Wayne R. Dashfield, PE

April 28, 2023

Subject: Existing LVL's and Roof Rafters
1242 Cool Springs Road
Lillington, North Carolina

2nd Floor Beam

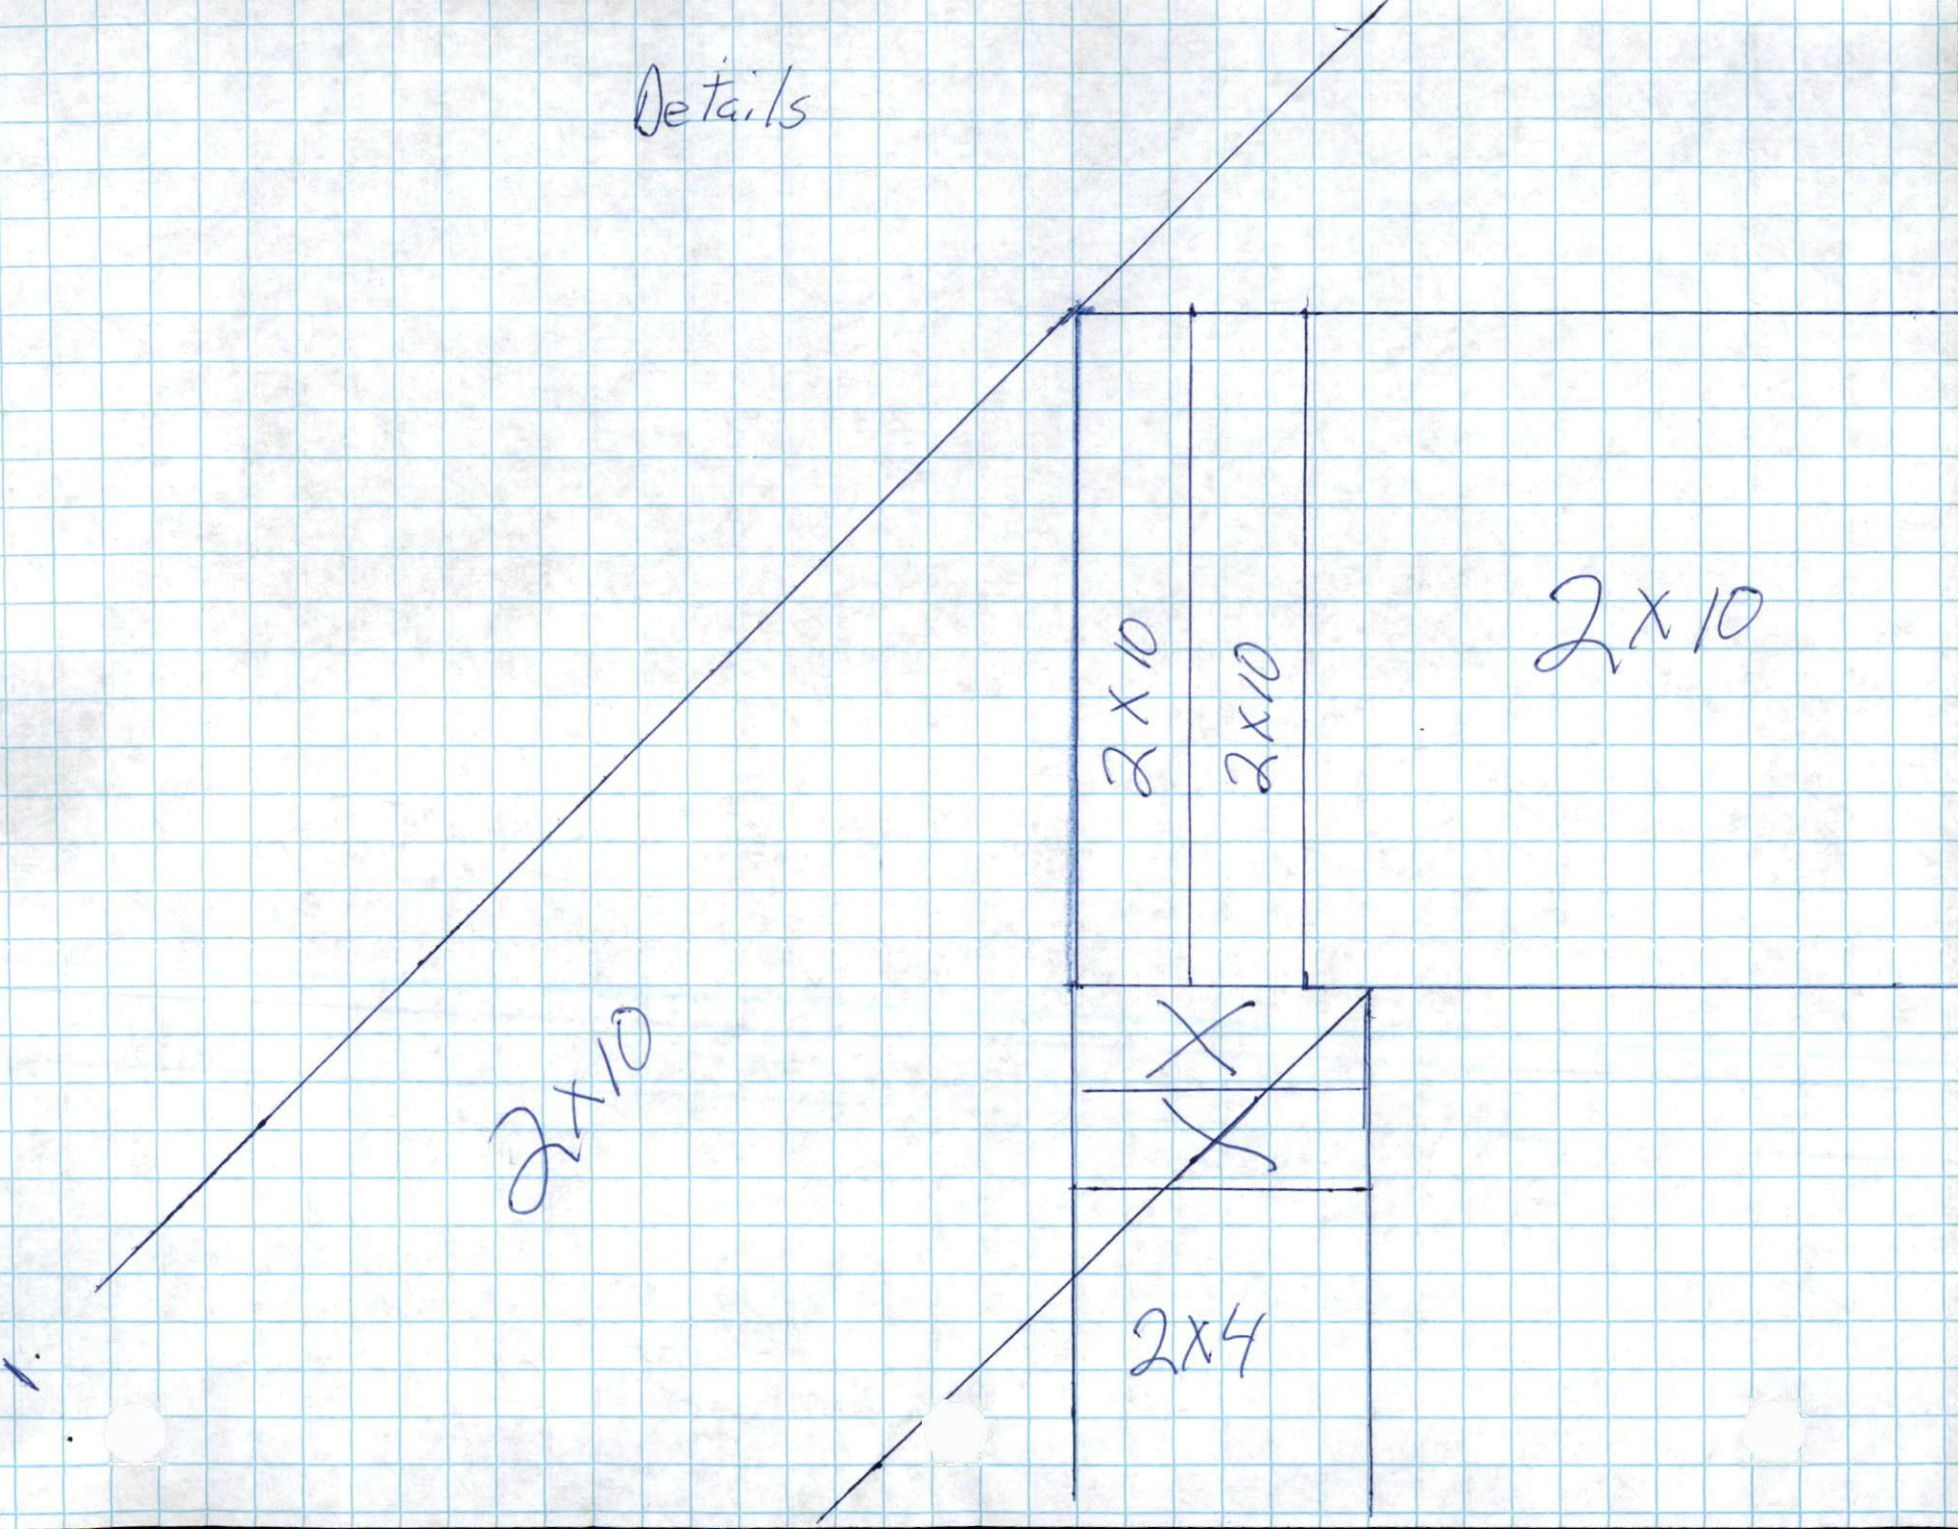
8' wide Catwalk at rear second floor

The 8' wide catwalk is supported by a (2) 14" 1.75x2.0e LVL spanning 16' on both sides of the catwalk. The existing catwalk requires LVL's with a bending moment greater than 12,500 ft-lbs. The existing (2) PLY 14" LVL has a bending moment of 27,162 ft-lbs. These LVL's are adequate.

2nd 8' wide Catwalk at rear second floor

The 8' cat walk is supported by a (2) 2x10 floor joists with a 9.25" 1.75x2.0E LVL on both sides of the cat walk. Listed below is a summary of the loads and size of the LVL and lumber sizes.

Bending moment required = 7680 ft-lbs

Bending moment for (2) #2 PLY 2x10 = 3433 ft-lb

Bending moment for (1) PLY 9.25 LVL = 6208 ft-lb

Total bending moment = 3433+6208=9641 ft-lb OK

1.75" x 16" LVL  
Tripled.

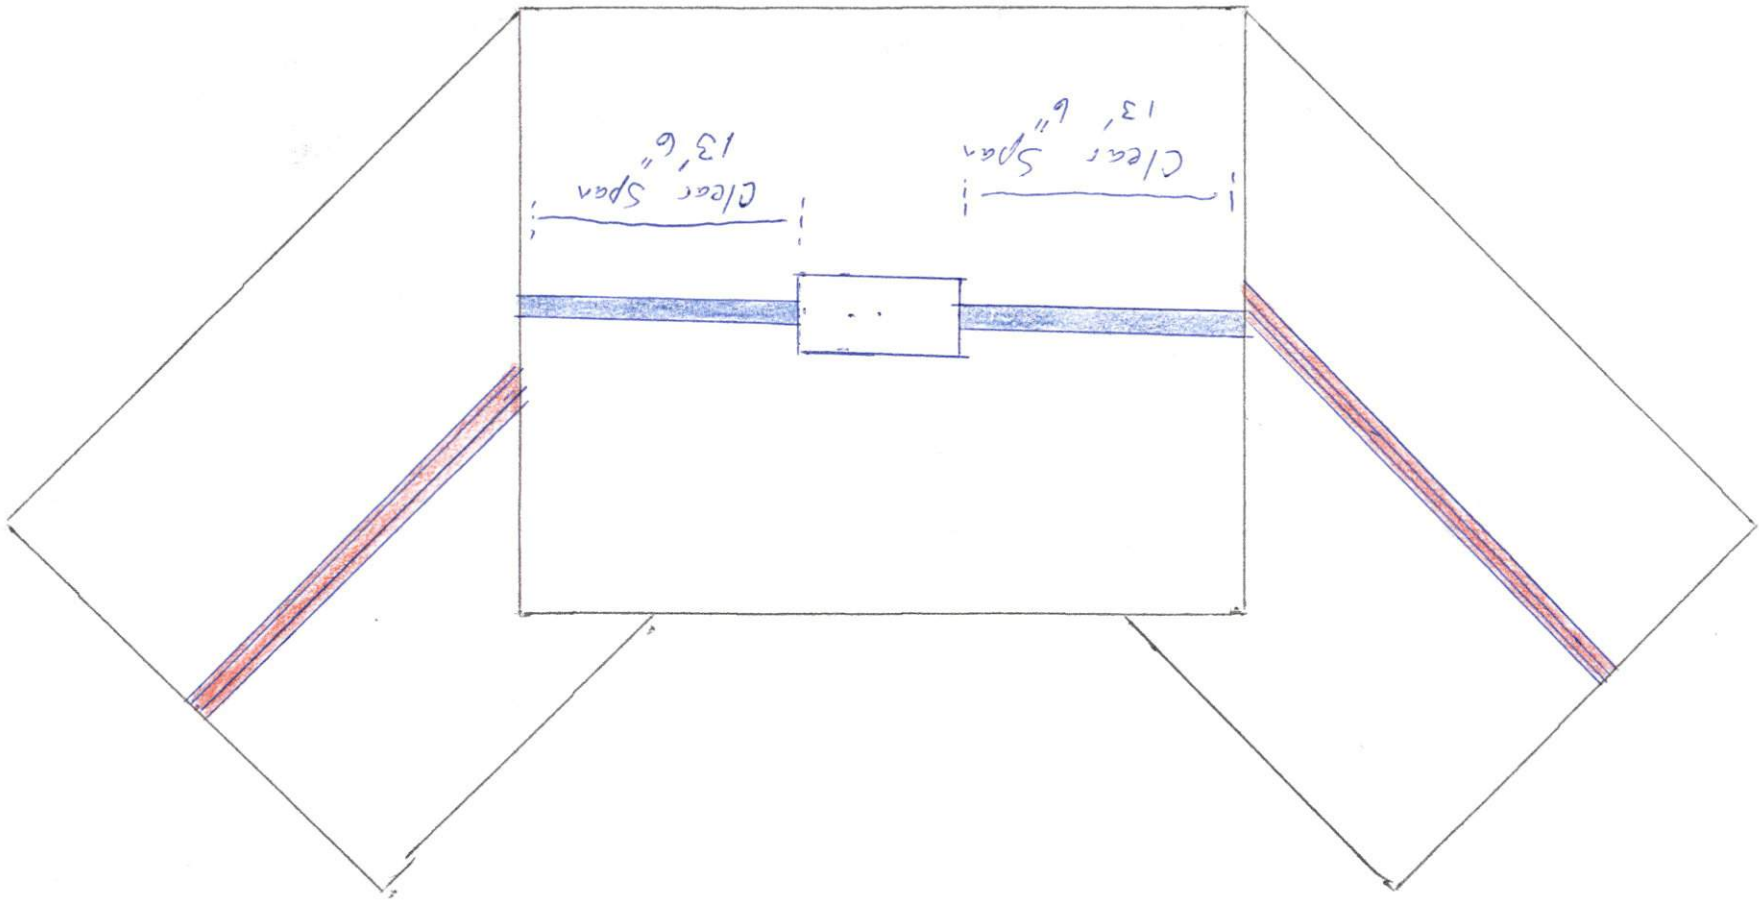
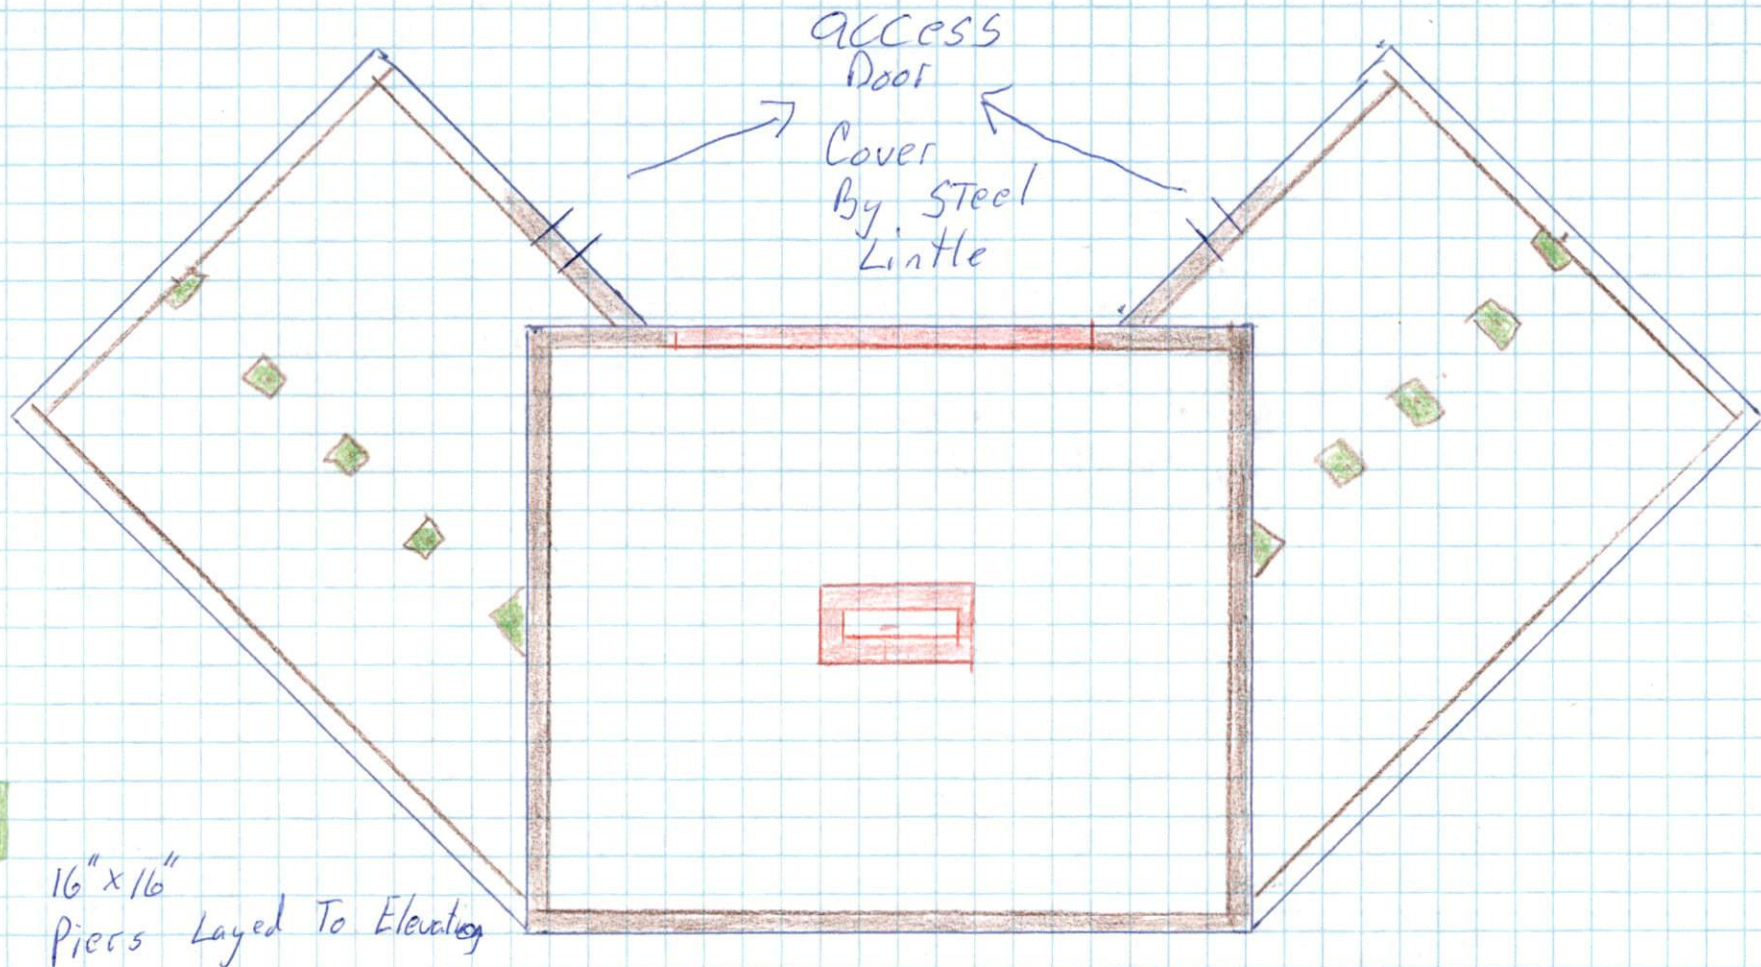
LVL's in the open basement area

In the open basement area the owner has installed four (2) ply 2.0E x1.75x 16" LVL for the first floor support. This loading condition would require a beam capable of a 19,624 ft-lbs bending moment. A (2) PLY 16" LVL can support a loading condition with a bending moment 34,954 ft-lbs. These (2) PLY 16" LVL' are adequate for this support.
